DEVELOPMENT REVIEW BOARD
SUPPLEMENTAL SUBMITTAL

PROJECT NO. PR-2021-005467
Application No. SI-2022-00861

Re: Raising Cane's (4800 Montgomery Blvd NE) PR-2021-005467

Please find the following responses addressing comments received in a letter dated May 4, 2022 from the One Albuquerque Planning:

**C5.1**

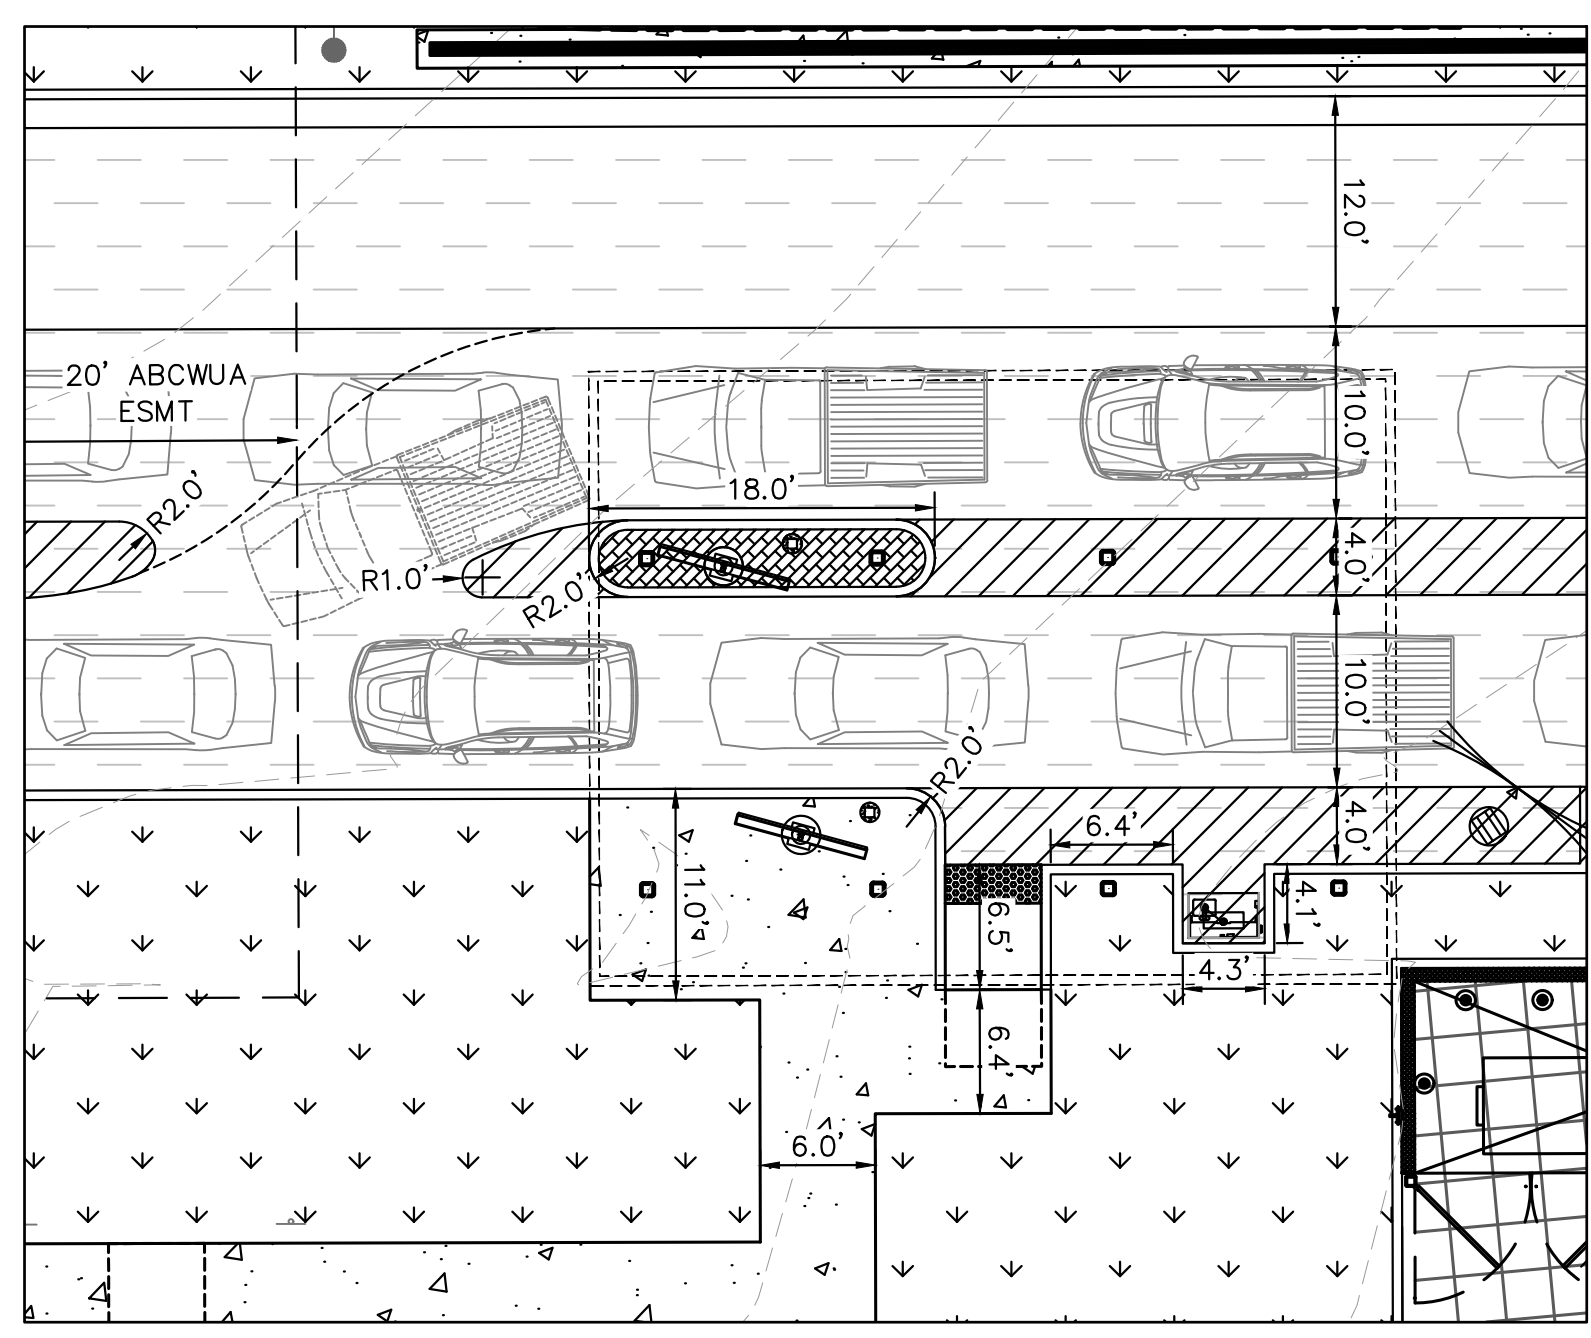
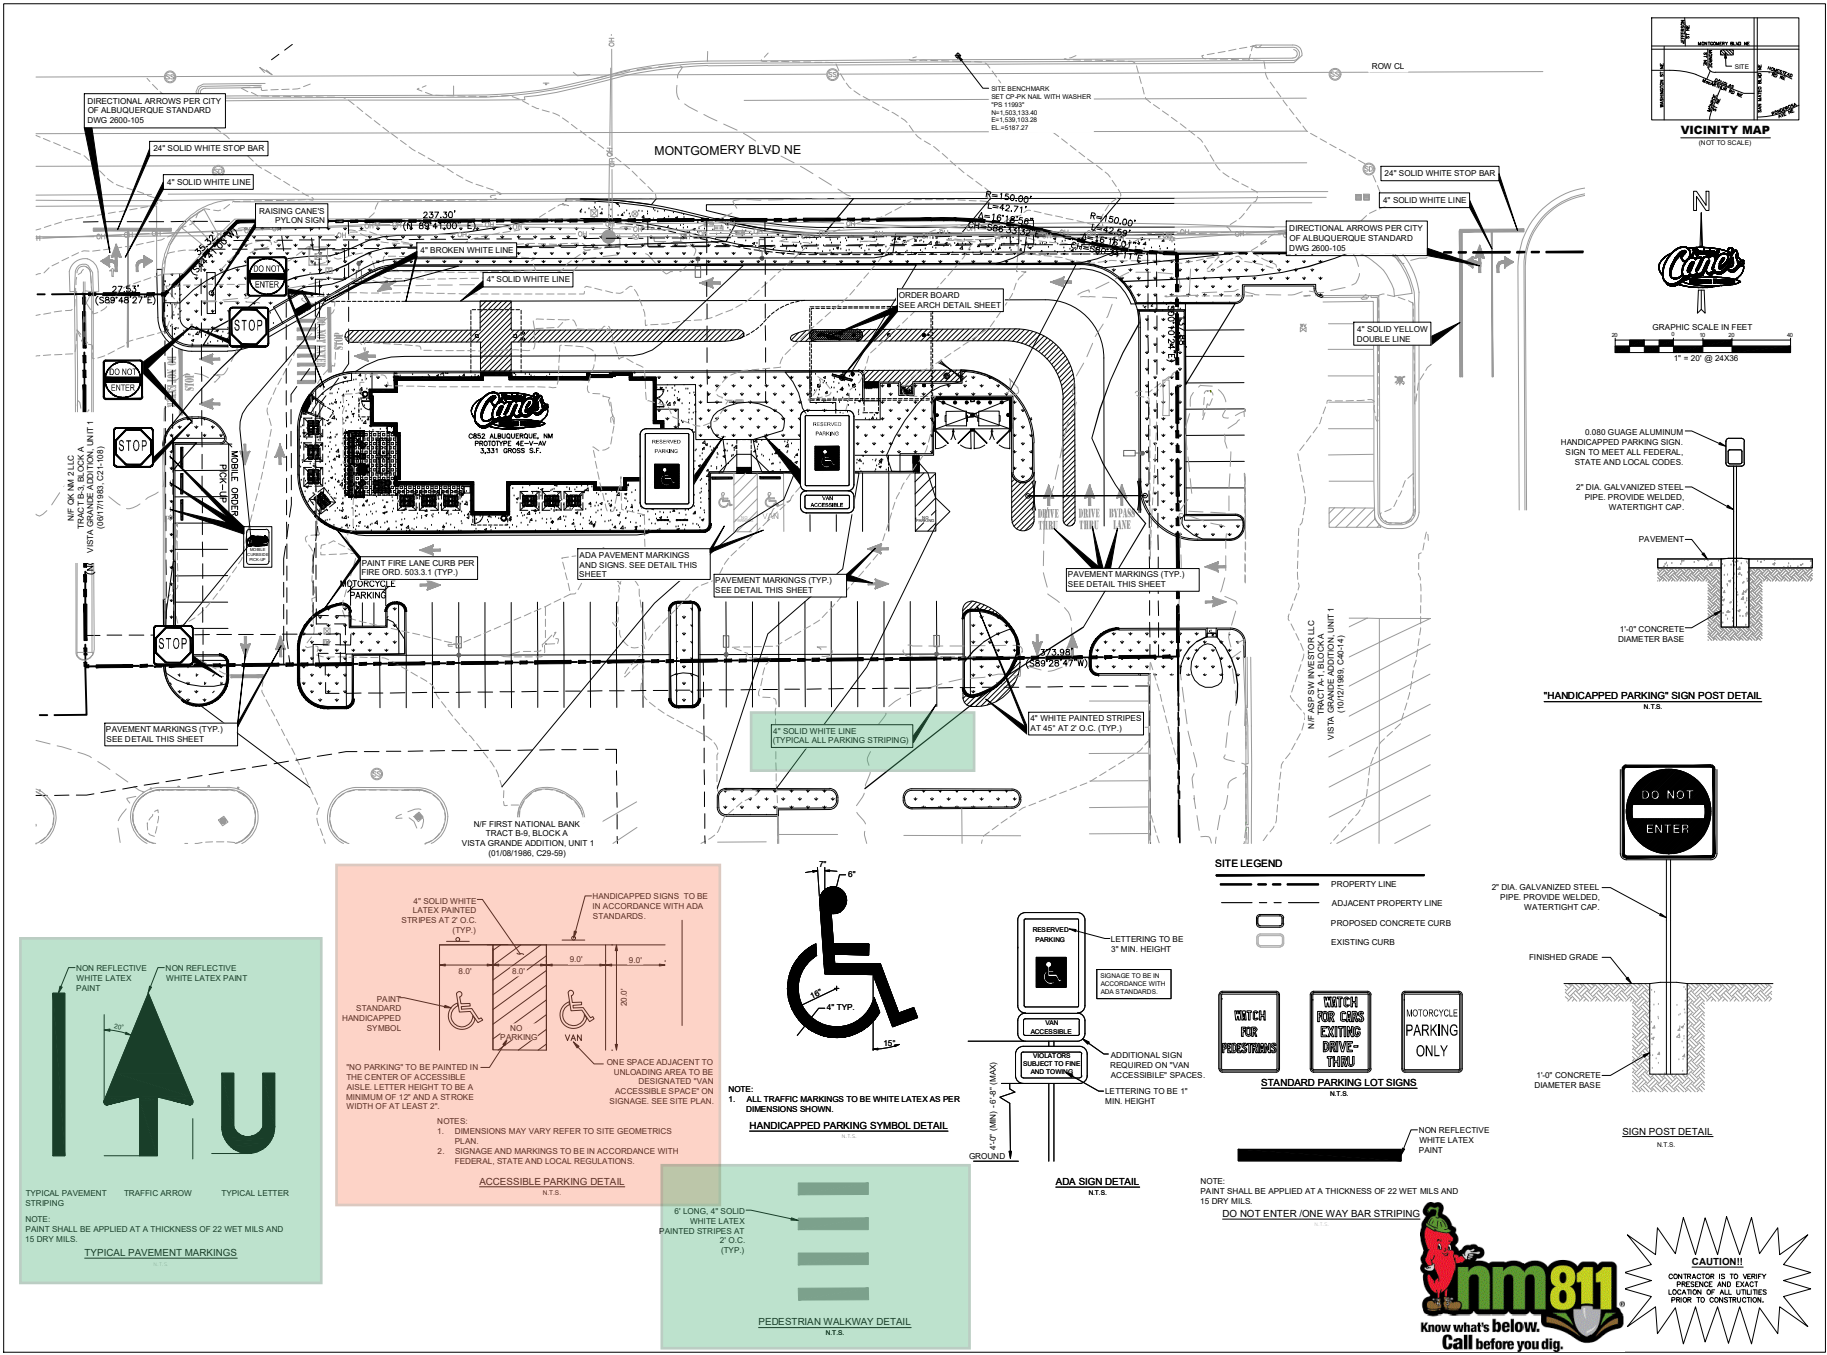
Comment 4: Freestanding Pylon Sign must be located at least 3 feet from property line (not indicated on site plan), as per IDO section 5-1(G), Table 5-1-4.

Comment 5: At least one 8-foot-wide van accessible aisle is needed for the handicapped spaces.

Response 4: Comment addressed in sheet C5.1 - Dimensional Control Plan.

Response 5: Comment addressed. Updates can be found in sheet C5.1 Dimensional Control Plan

Sheet Title: **STRIPING AND SIGNAGE PLAN**  
Date: 05.10.2022  
Project Number: 090042000  
Drawn By: LWLN  
Sheet Number:

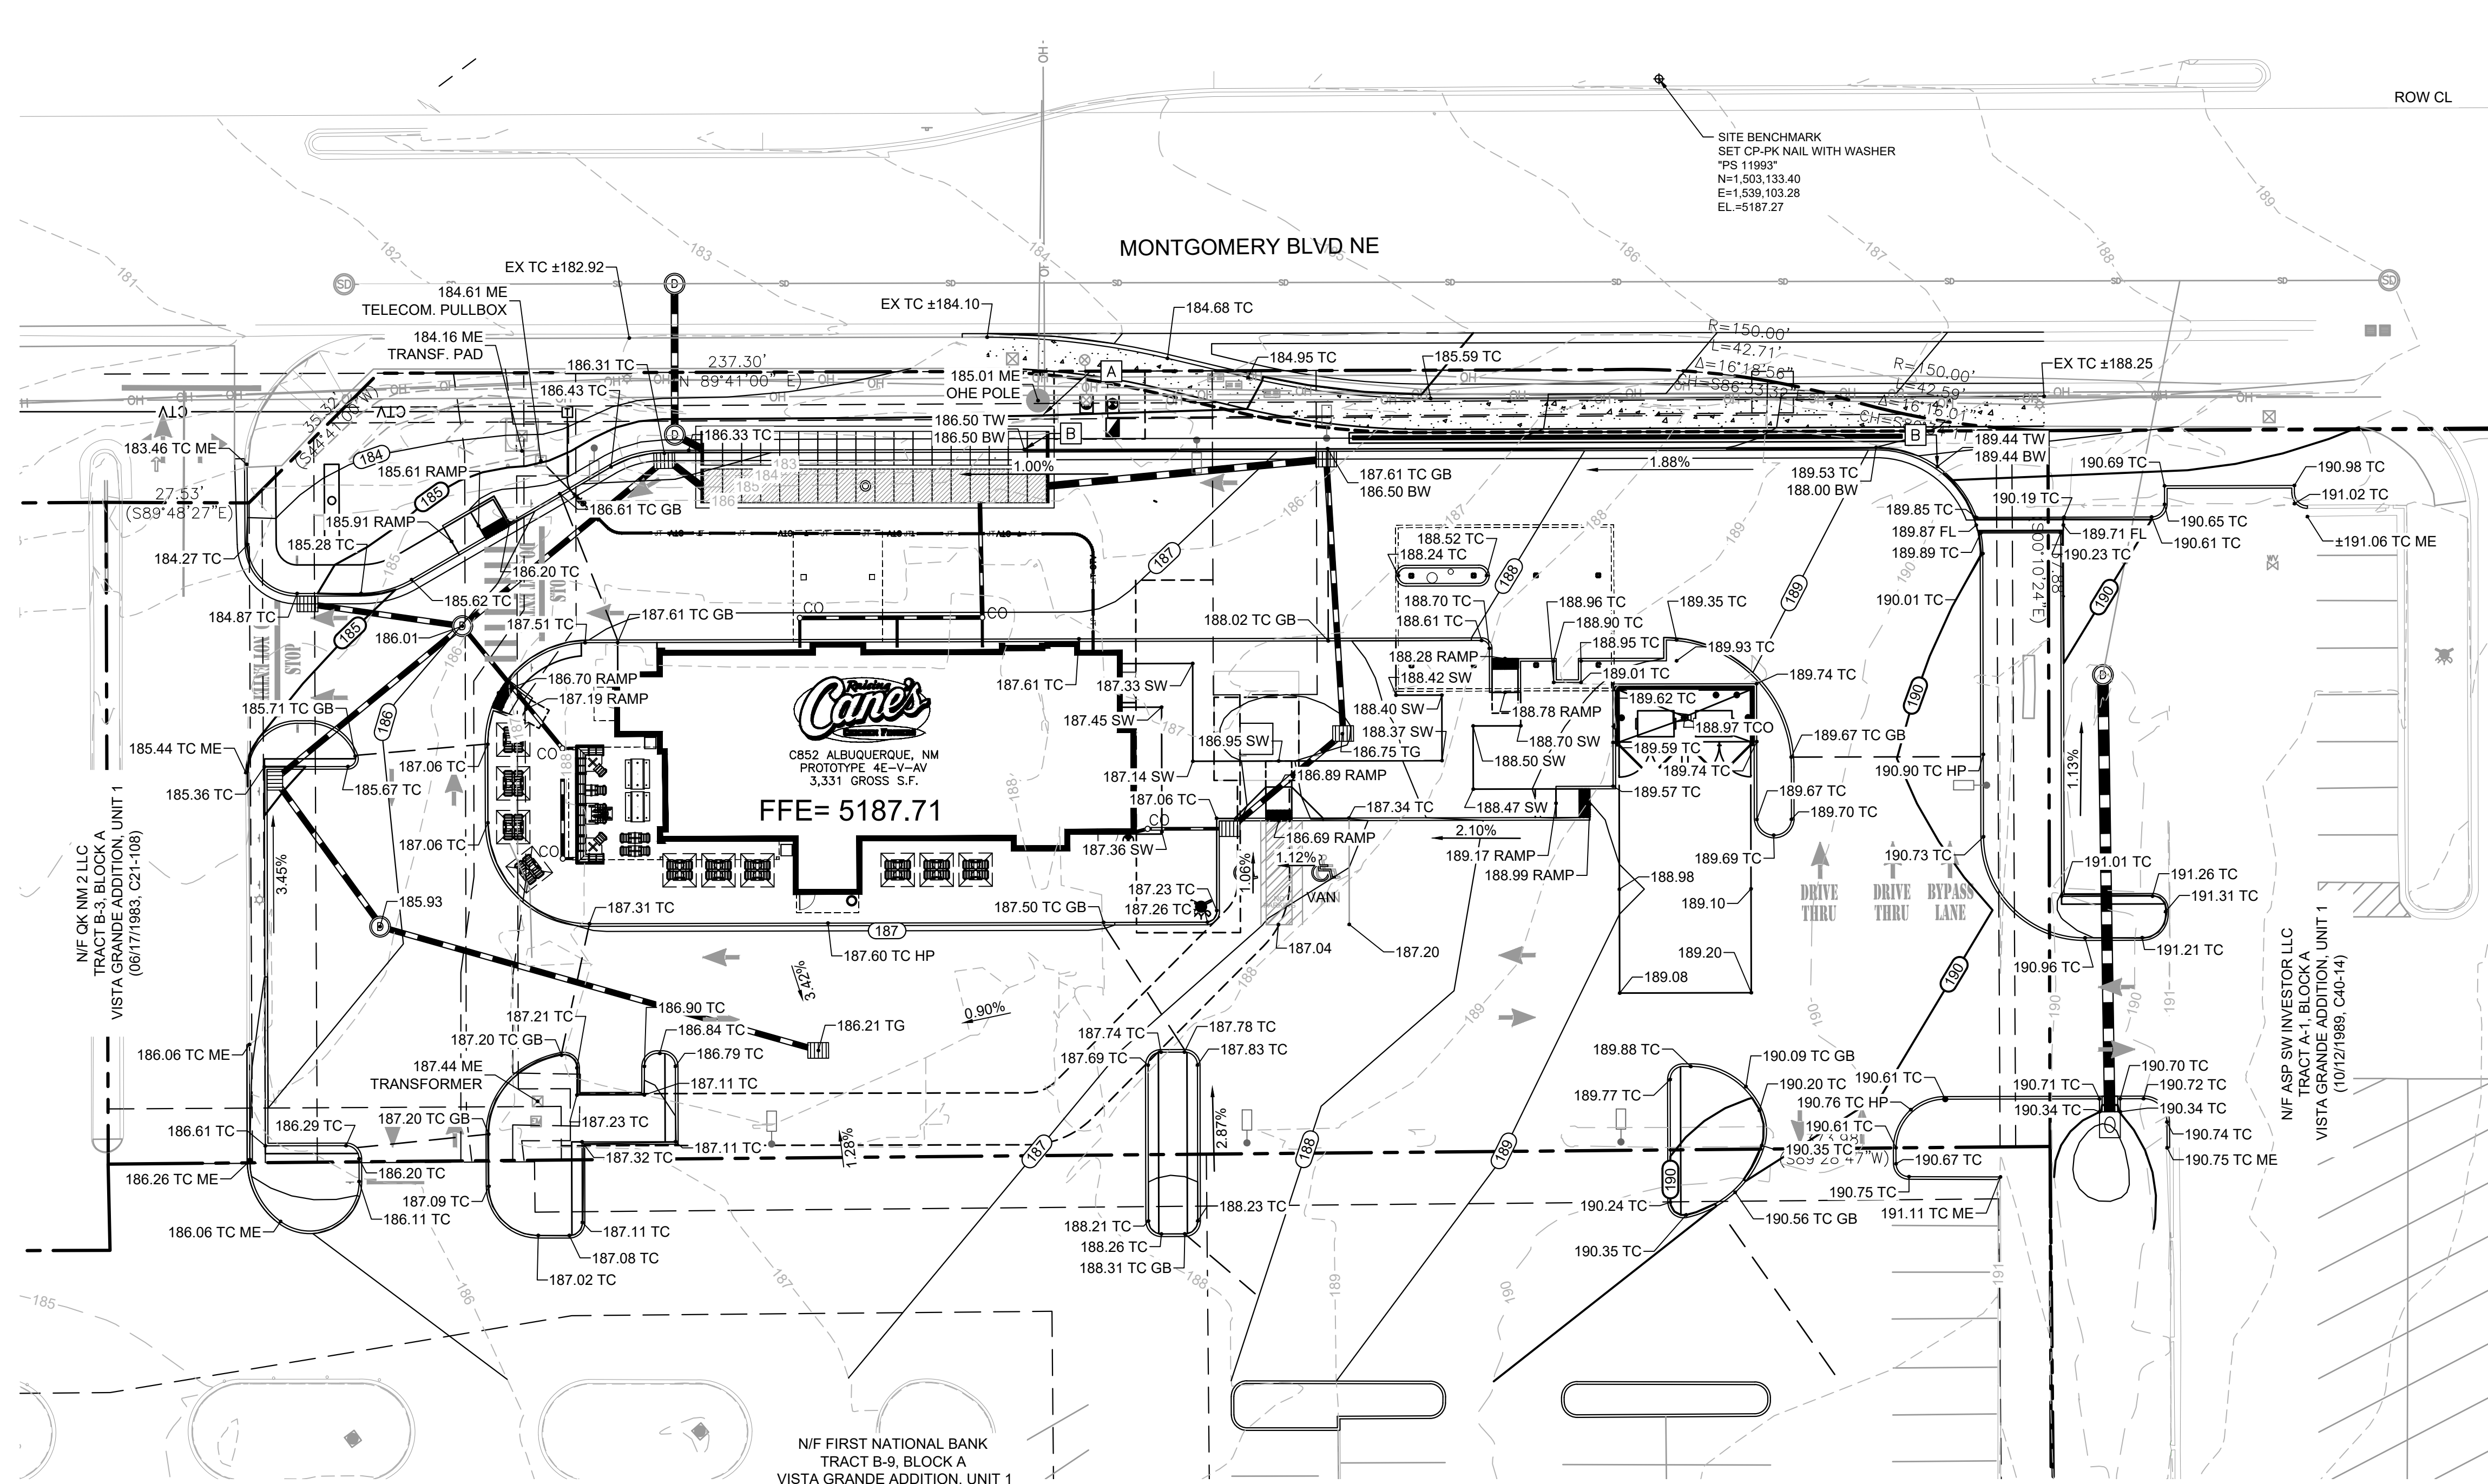
Comment 6: Include motorcycle parking sign as part of the detail sheet. The curb pick-up sign is illegible.

Comment 7: Detail on-site parking striping. Specify color, spacing of diagonal striping, etc.

Response 6: Motorcycle Parking Only sign has been added and the Mobile Curbside Pick-Up sign has been altered, see sheet C5.2 – Striping and Signage Plan.

Response 7: Comment addressed on sheet 5.2 – Striping and Signage Plan

LANDSCAPE BUFFER EXHIBIT

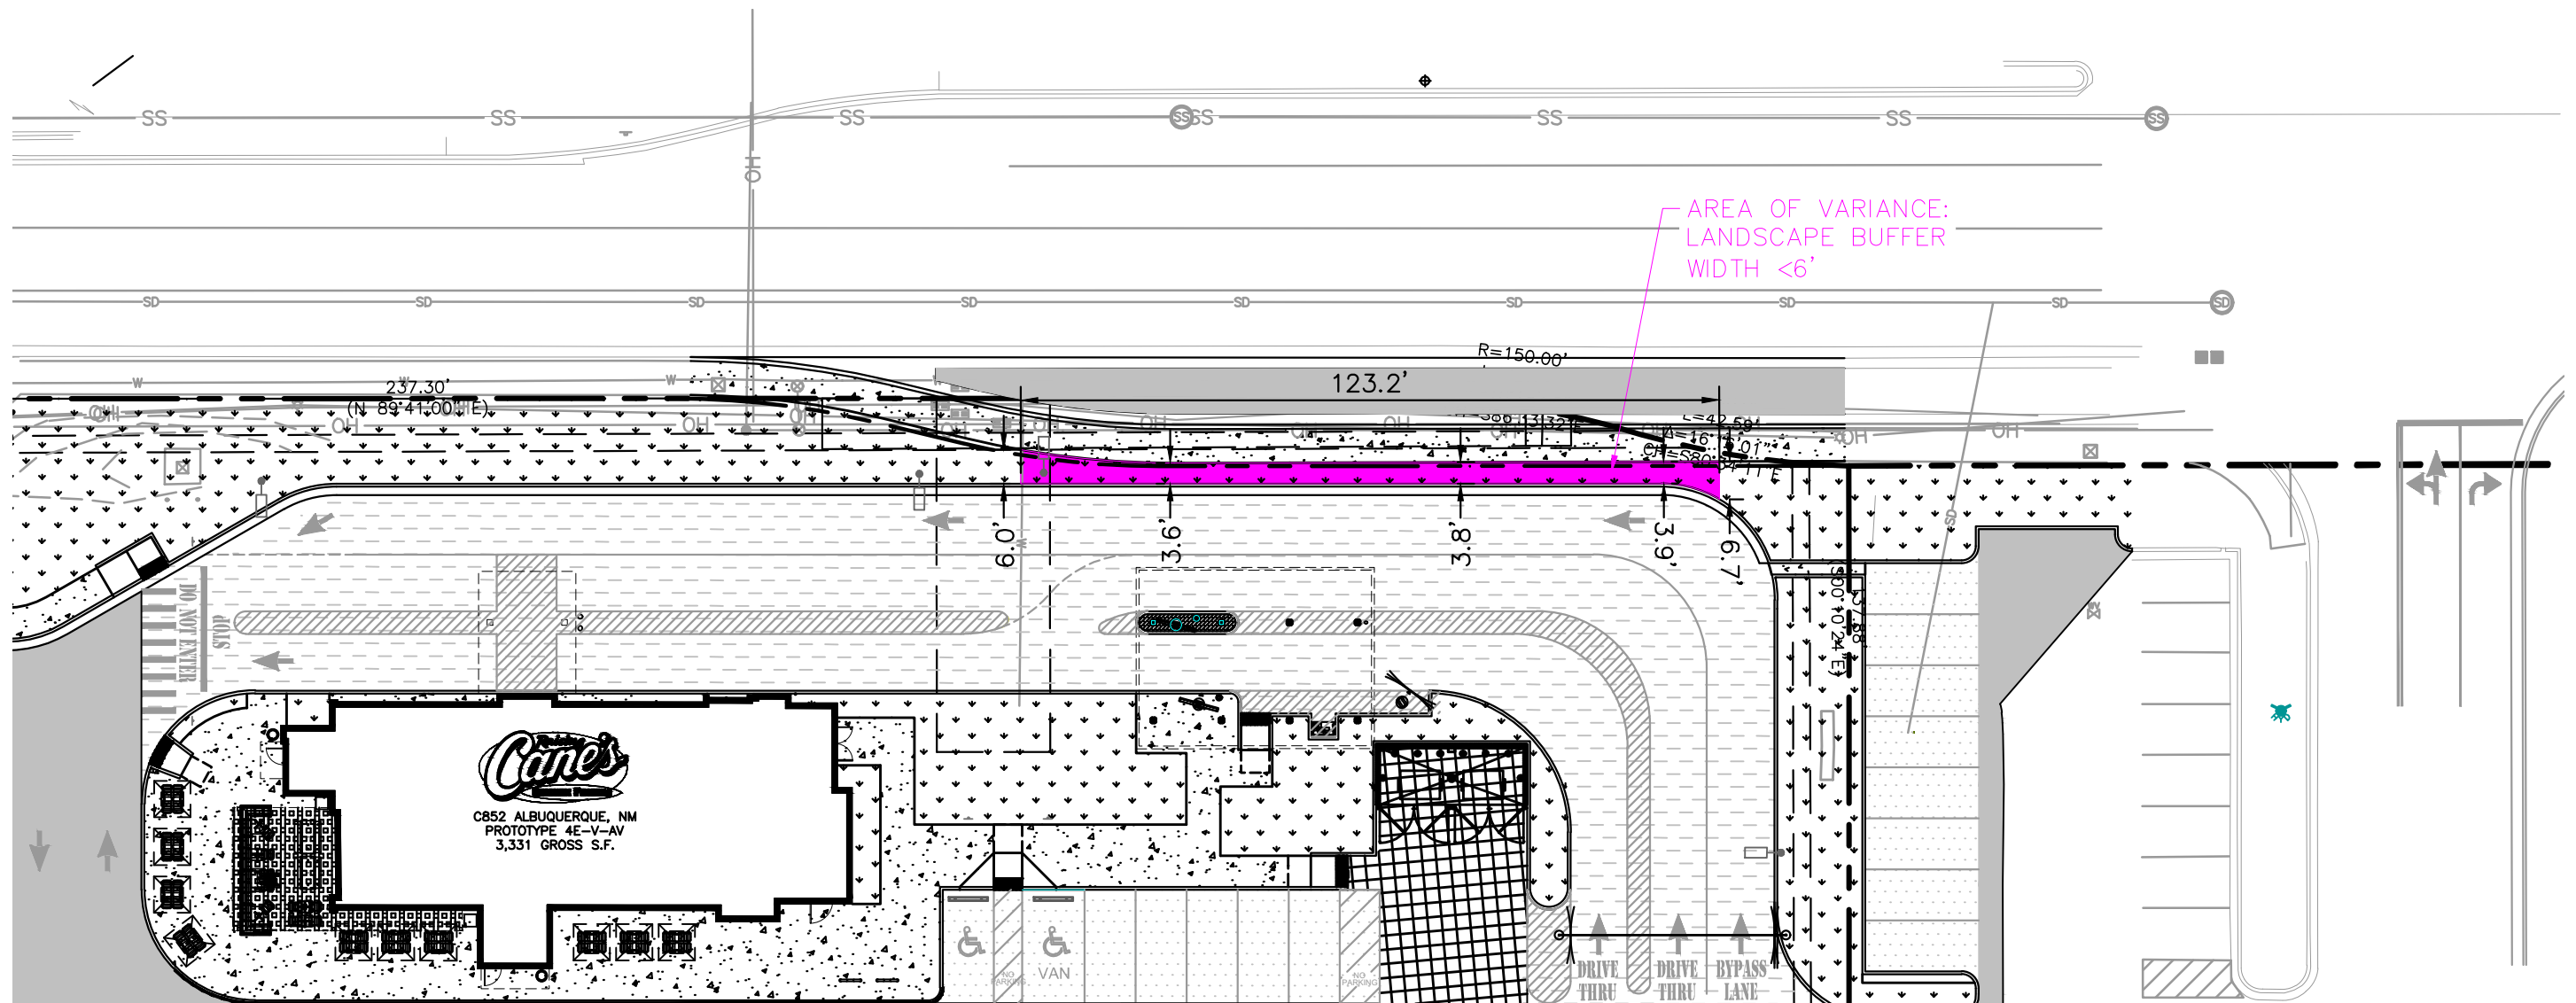
Comment 8: 5-5(l)(2)(a) of the IDO requires a landscape buffer at least 6-feet in width to screen drive-through lanes adjacent to public rights-of-way. The applicant asserts that a portion of the buffer on the northeastern portion of the site adjacent to Montgomery Boulevard cannot meet the 6-foot width requirement, and the buffer is as narrow as 3.6 feet in width. The applicant has applied for a Waiver from this requirement which is scheduled to be heard at the May 18 DRB meeting. **The EPC Final Site Plan Sign Off cannot be approved until/unless the Waiver is approved.**

Response 8: Comment noted.
